SSD-9726 Adaptive Reuse of the Royal Hall of Industries

The Government Architect has been asked to provide independent design review commentary on the State Significant Development Application SSD-9726.

FLOOR PLAN  
GROUND LEVEL

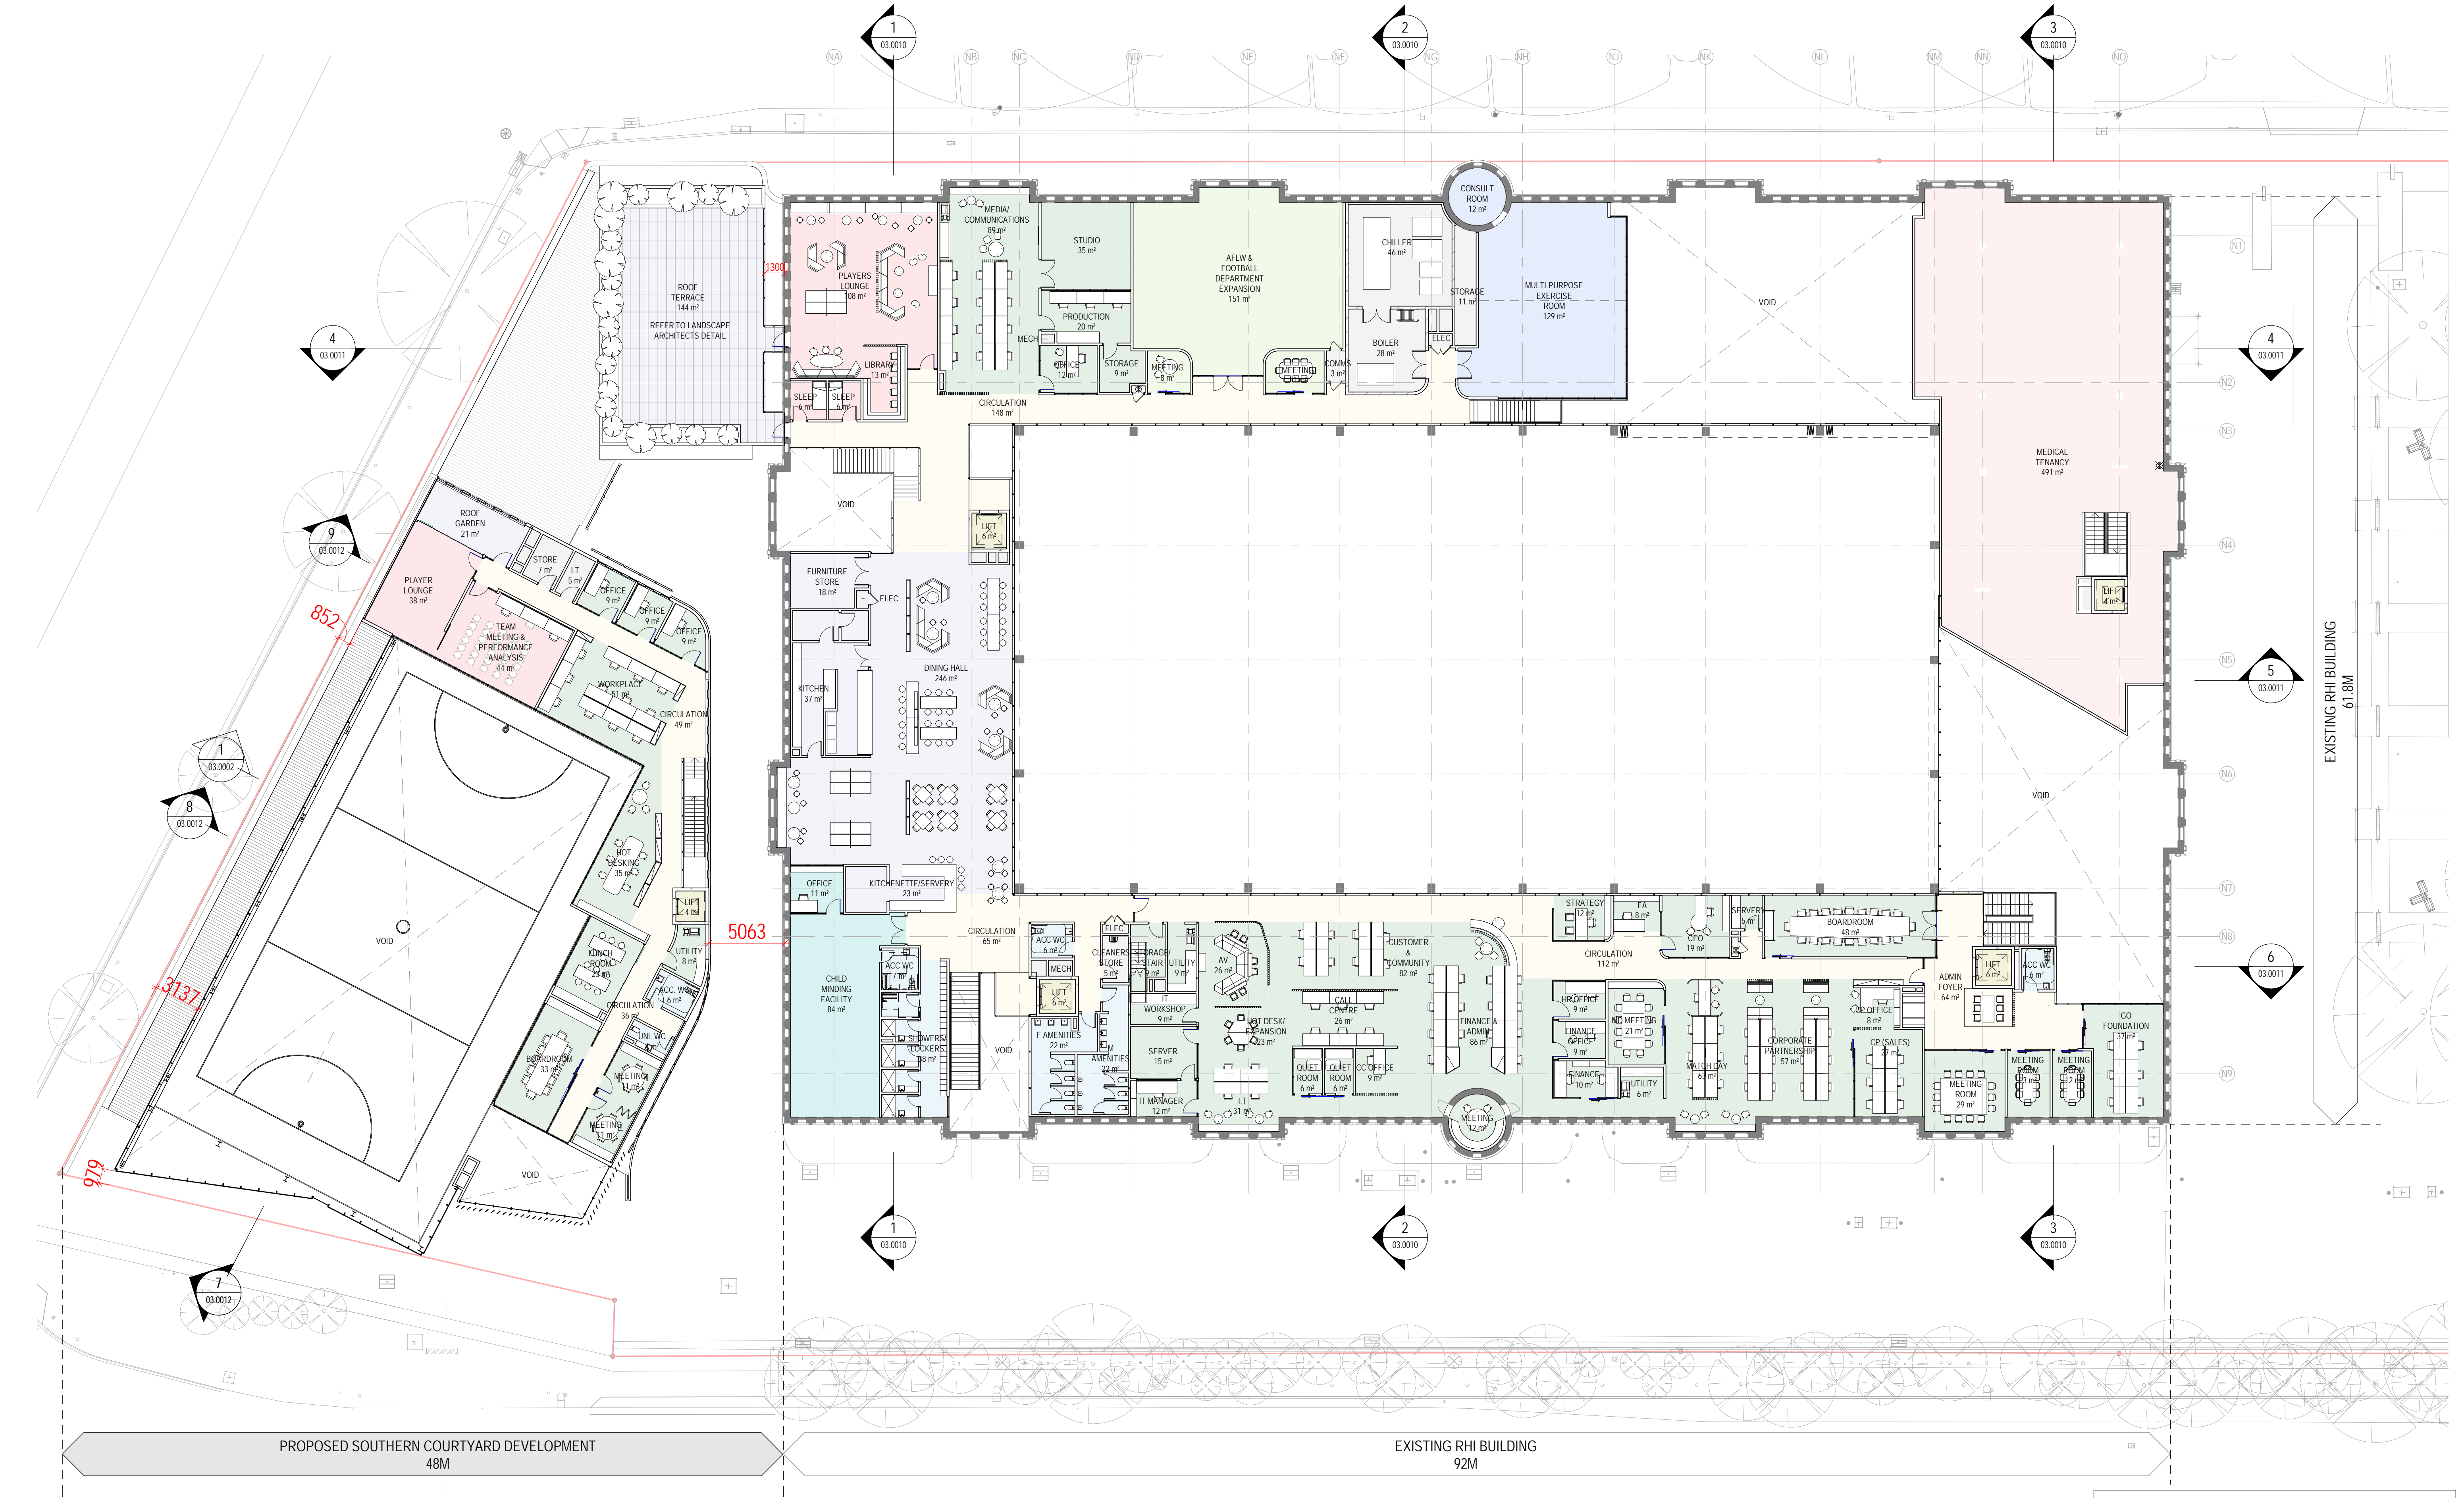
- Reconsider the location of the proposed RHI toilets to ensure they service the office fit out and are easily accessed during events.
  - Enlarge the entry from the plaza into the RHI to strengthen the internal/external relationships and showcase the volumes of the existing RHI.

- Provide a walkable space/corridor around the outside of the internal columns in the RHI.
  - Articulate the façade of the NSB to reflect its corner location and entrance to the greater site.
